MEMORANDUM

To: FILE
From: Caitlin Cameron
Subject: Application ID: 2014-066
Date: 6/2/2014

Re: PEZ.2014.-066, Block/Lot #20-F-23, 185 Fore Street

Memo To: Caitlin Cameron
Barbara Barhydt
From: David Margolis-Pineo
Re: 167 Fore Street – Review Comments 2014-066
Department of Public Services

(F) BARRIER FREE RAMP DETAILS
N.T.S.

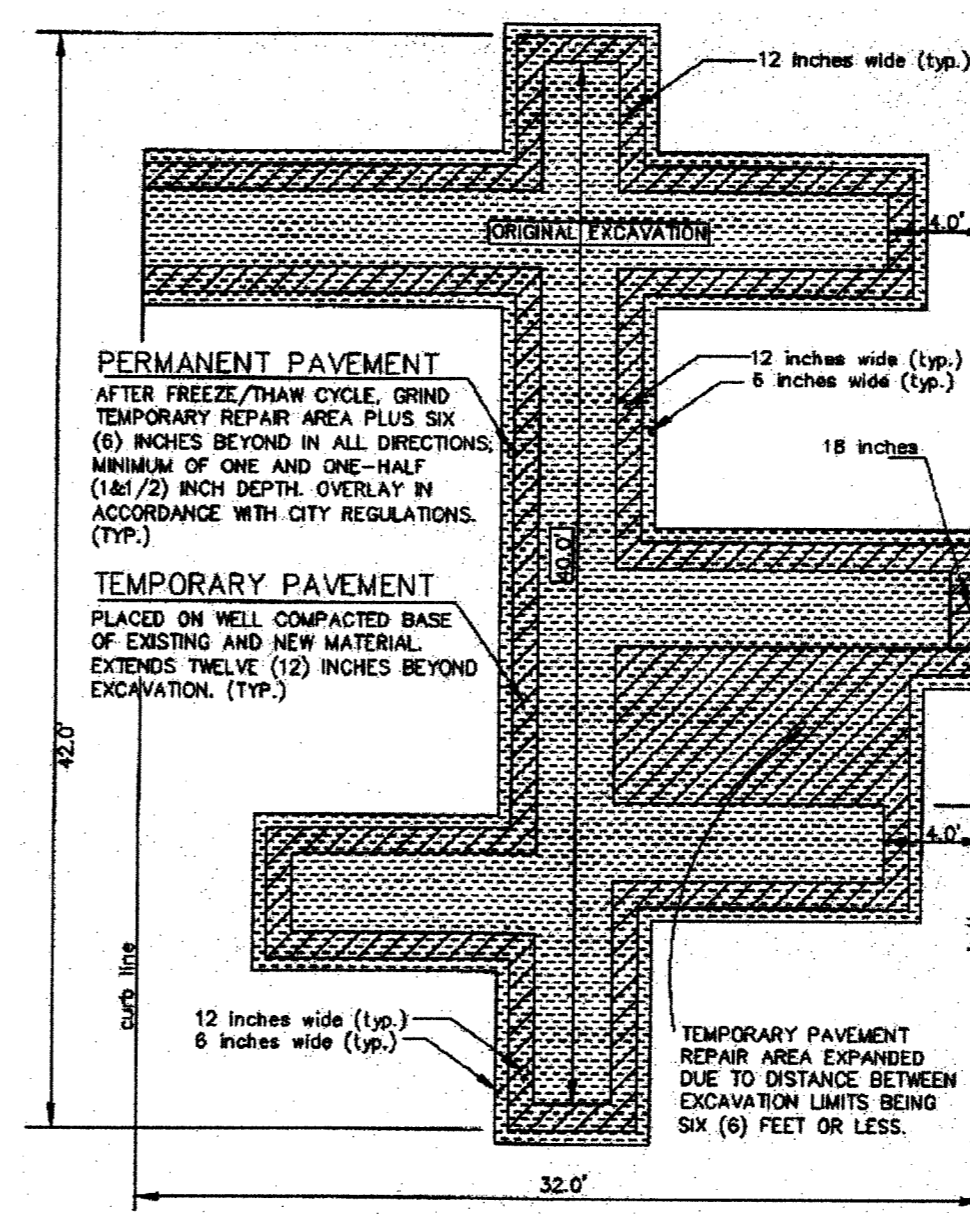
8. Both of the cross walk ramps at the corner of Hancock and Middle Street do not meet current City of Portland standards. The applicant is requested to rebuild these two ramps to meet current City standards.

Curb ramps must be designed in detail showing the dimensions of tipdown curbs, flush curb and dimensions of detectable warning panels. Also show the location of any drainage structures and utilities that may impact curb ramp location and design.

(K) BIKE HITCH MOUNTING DETAIL
N.T.S.

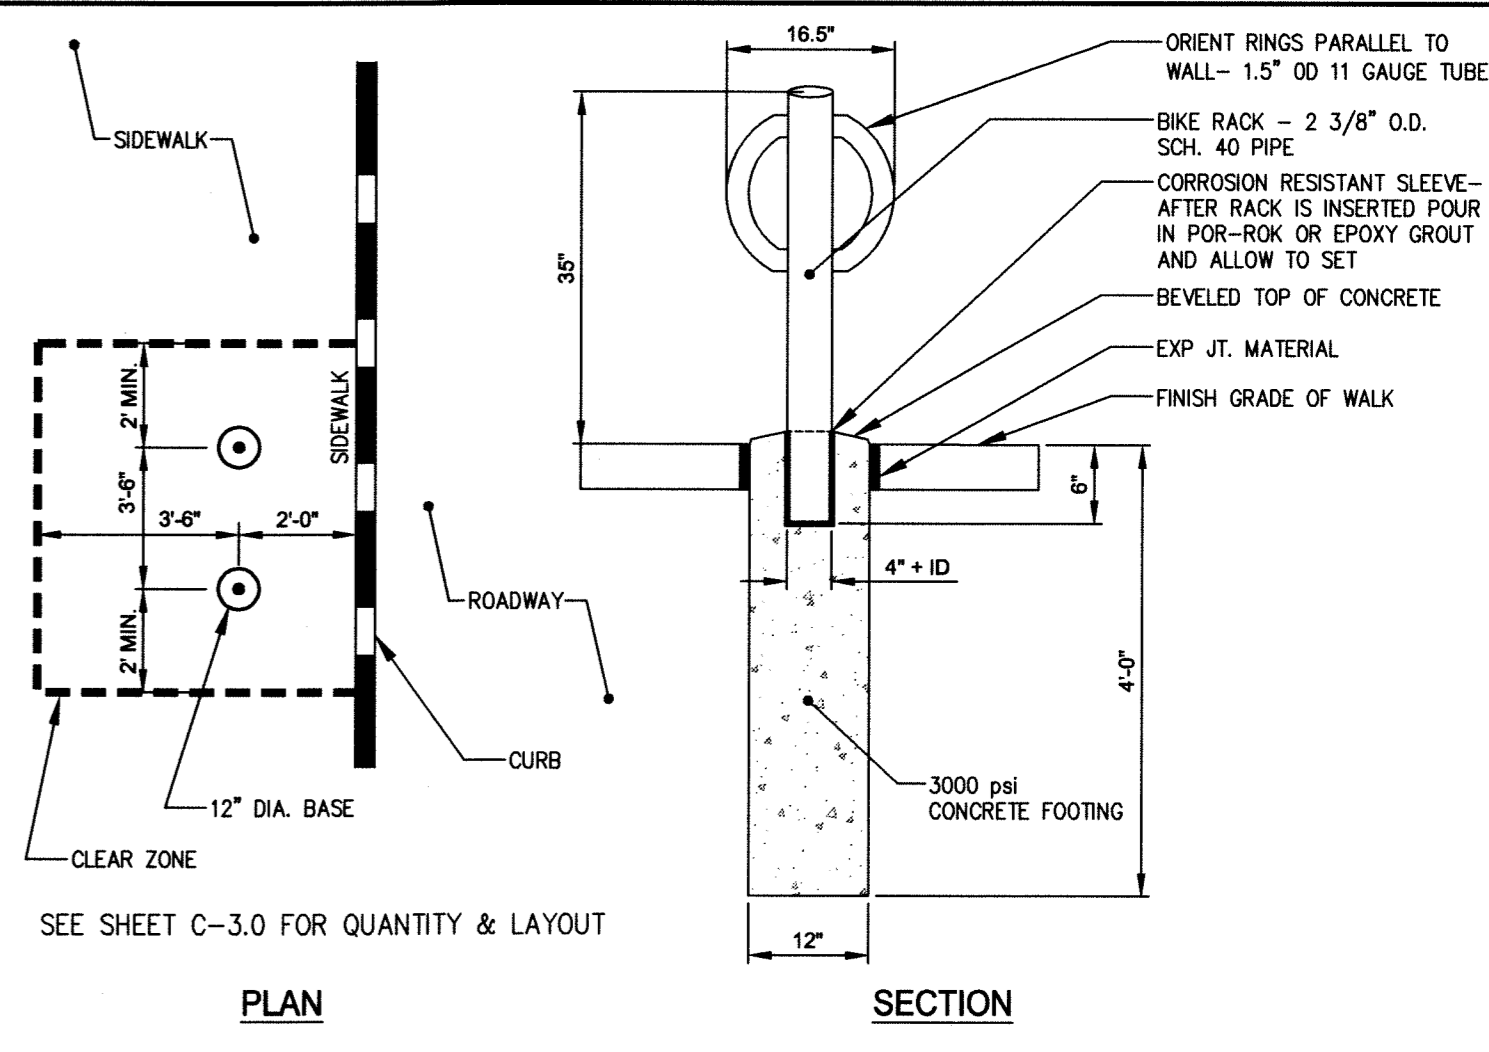
5. The applicant is requested to place additional bike parking on Fore St in the proximity to office/retail door and to locate towards the back of the sidewalk and away from the curb line.
Bike rack spacing guidelines:

- If bike racks are located next to and parallel to the building, they shall be a minimum of 30" from the building (36" preferred). The minimum spacing between racks (on center) shall be 6'.

- If bike racks are located next to and perpendicular to the building, they shall be a minimum of 48" (on center) from the building (60" preferred). The minimum spacing between racks (on center) shall be 36" (48" preferred).

- If bike racks are placed at the curb and parallel to the curb, they shall be located a minimum of 24" from the back of curb (36" preferred). The minimum spacing between racks (on center) shall be 6'. They should be placed/spaced to avoid car doors opening based upon expected parking spacing.Bike racks may not be placed when bicycles are parked to reduce the clear sidewalk width below 5'.

**(E) PIPE CONNECTION TO EXISTING STRUCTURE DETAIL**  
N.T.S.

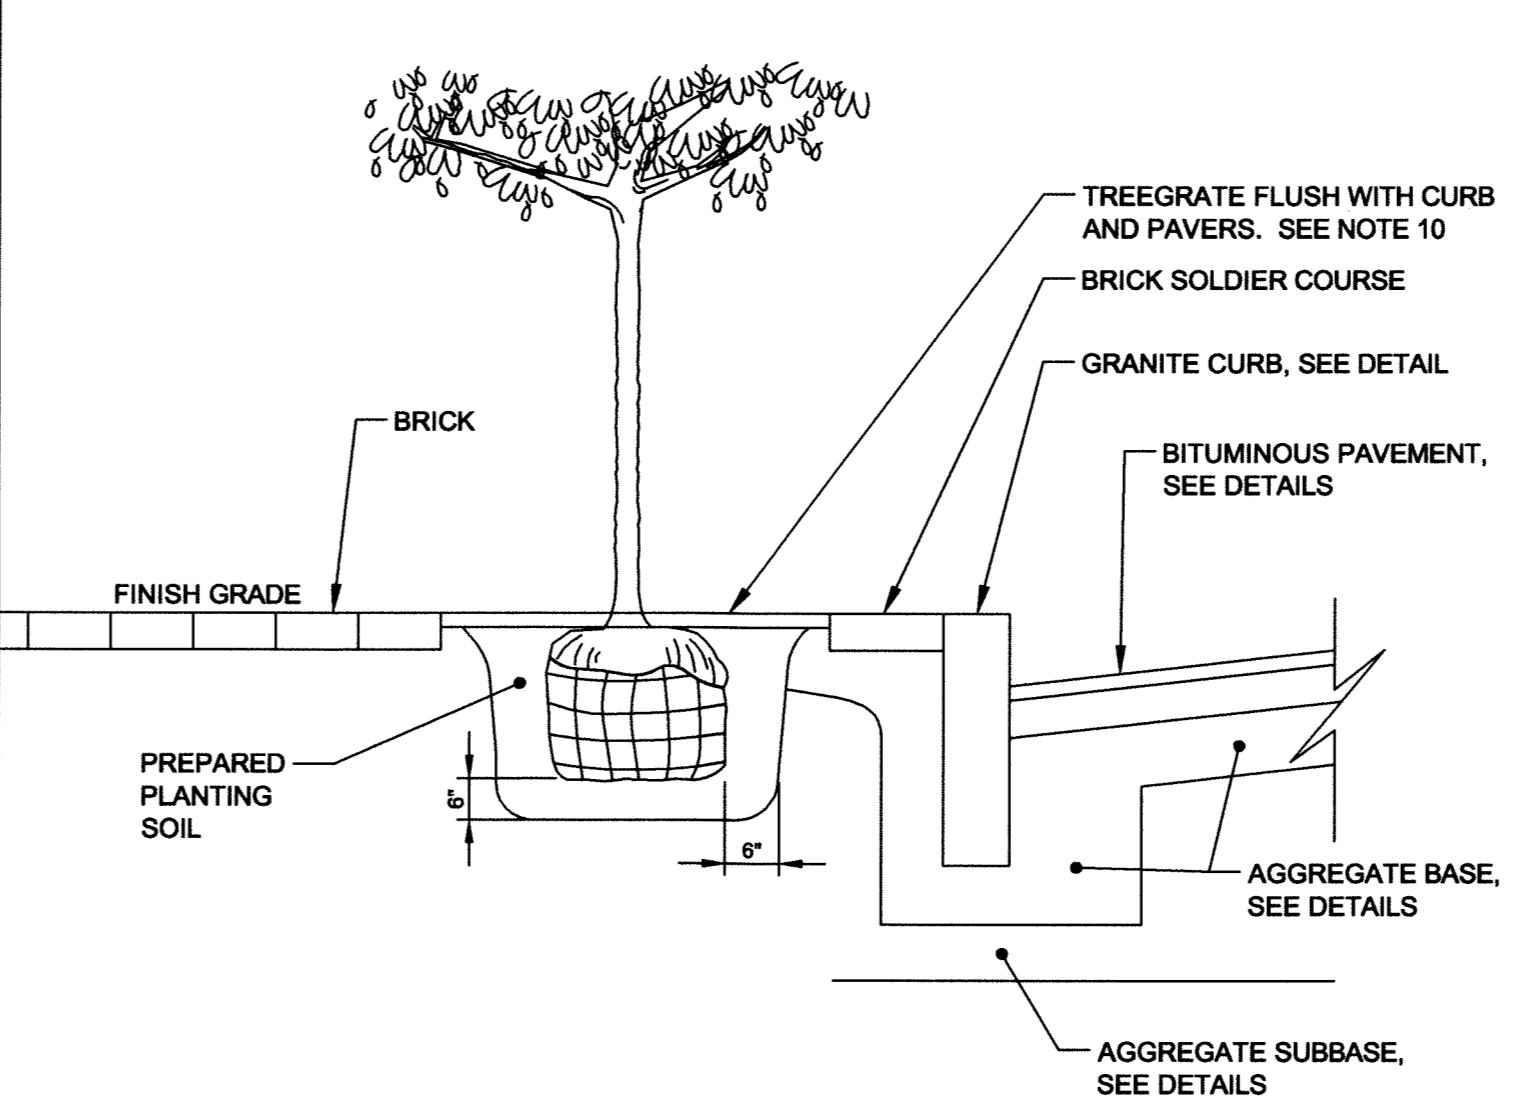
9. The applicant is requested to direct all site stormwater drainage into the catchbasin at the corner of India and Fore St. The penetration to the catchbasin shall be core drilled with a snap in boot connection.
